# Landscape Plans\_V3\_Redlines.pdf Markup Summary

PCD File No. PPR2031

L1.1

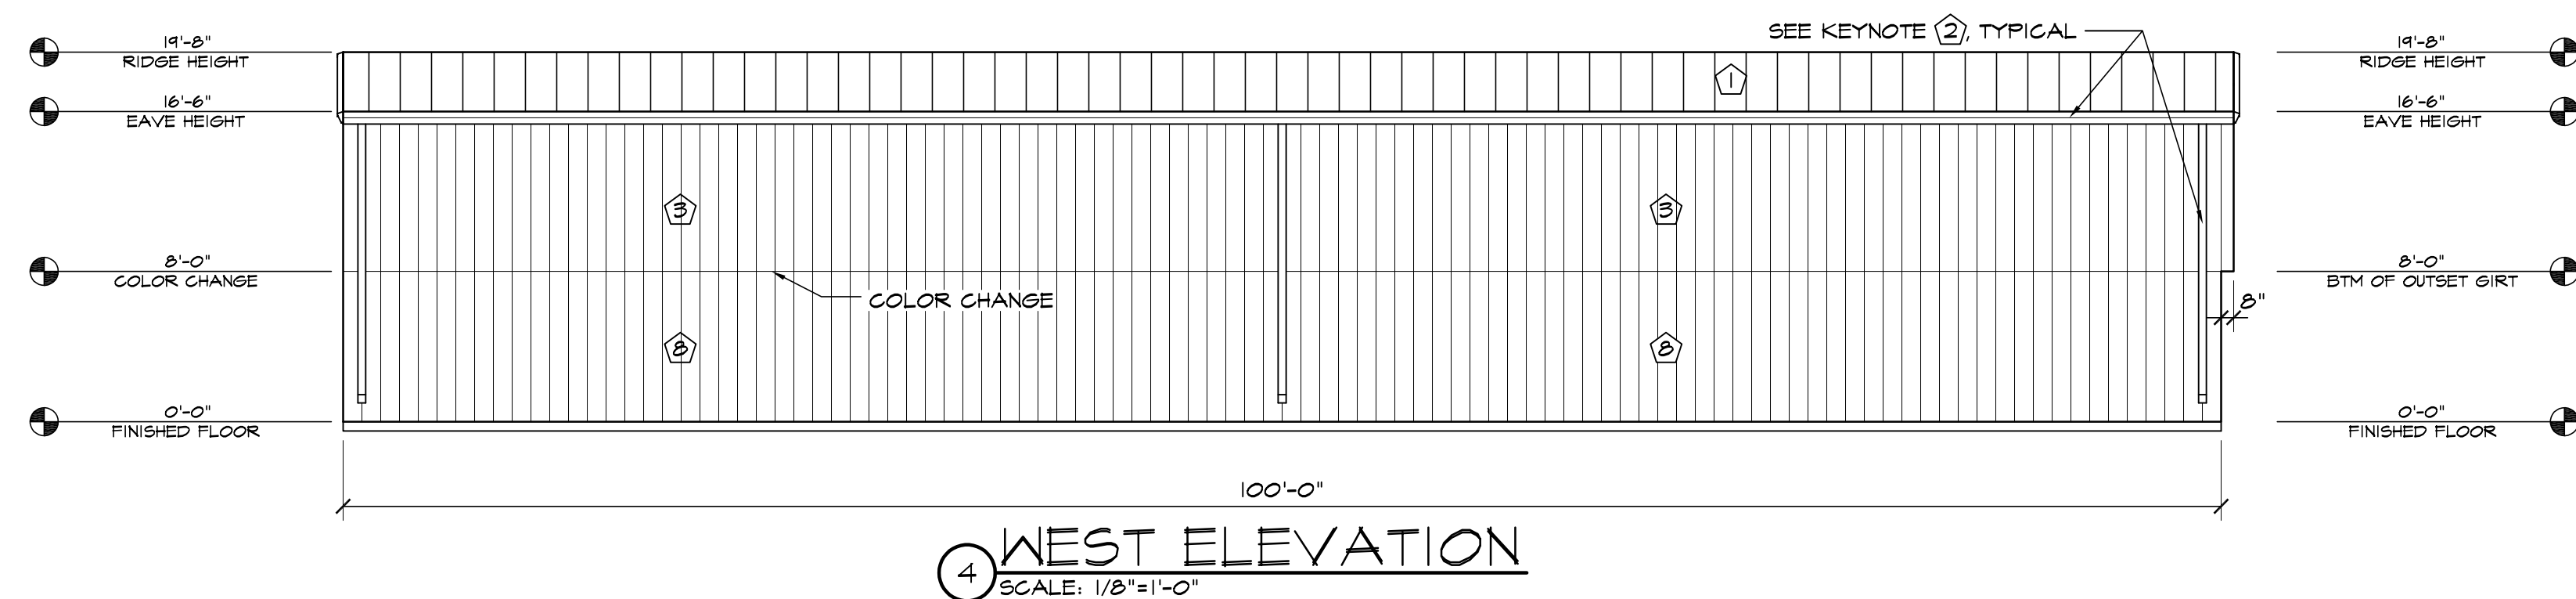
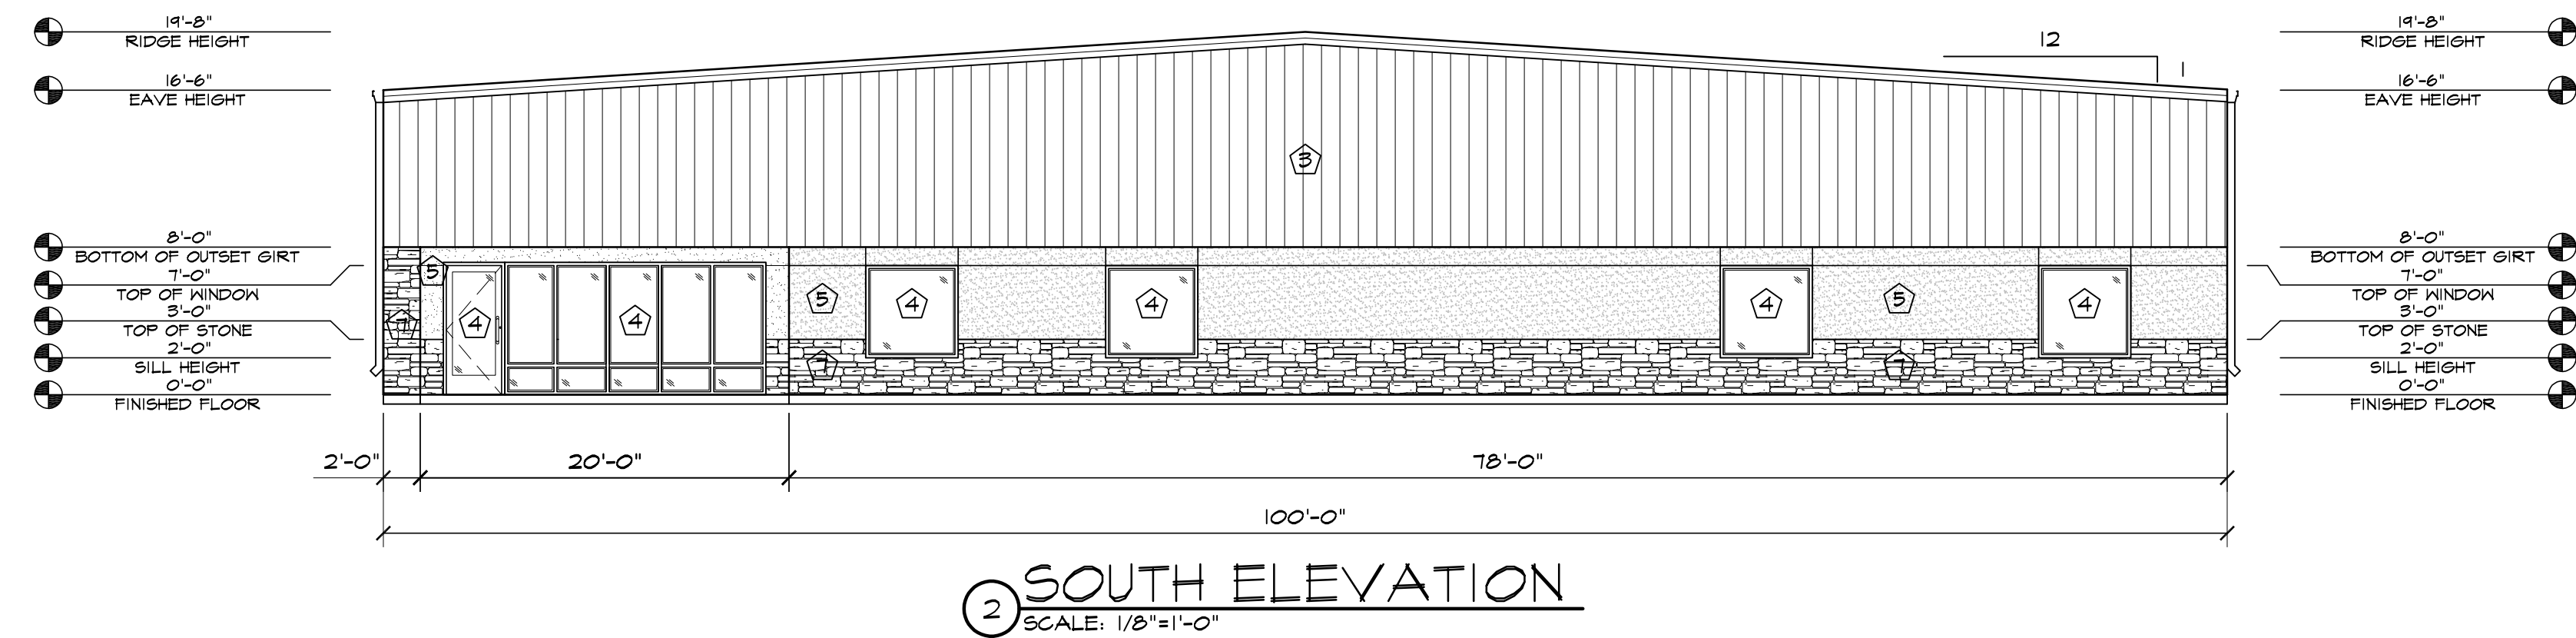
2. [Repeat Comment]: Internal Landscaping site data table shows that four (4) trees are provided, however only three (3) trees shown on plan. Please show those four (4) trees noted as provided in the table and justify in Letter of Intent why four are proposed in lieu of six trees as required.

3. [Repeat Comment]: Internal landscaping should be calculated using the entire parcel per Code Section 6.2.2(E)(3)(c). Please revise note on how internal landscaping is calculated.

5. Please revise to show symbol for Junper shrub.

1. [Repeat Comment]: Number of Evergreen Plants is inconsistent with Motor Vehicle landscaping site data table. Please correct number provided for consistency with plan and below Evergreen Shrub in plant schedule table (6).

4. There are 3 MS trees shown on this plan; please revise plant schedule table for consistency with plan.

6.[Repeat Comment (made by Engineering in Review 1)]: Please add PCD File No. PPR2031
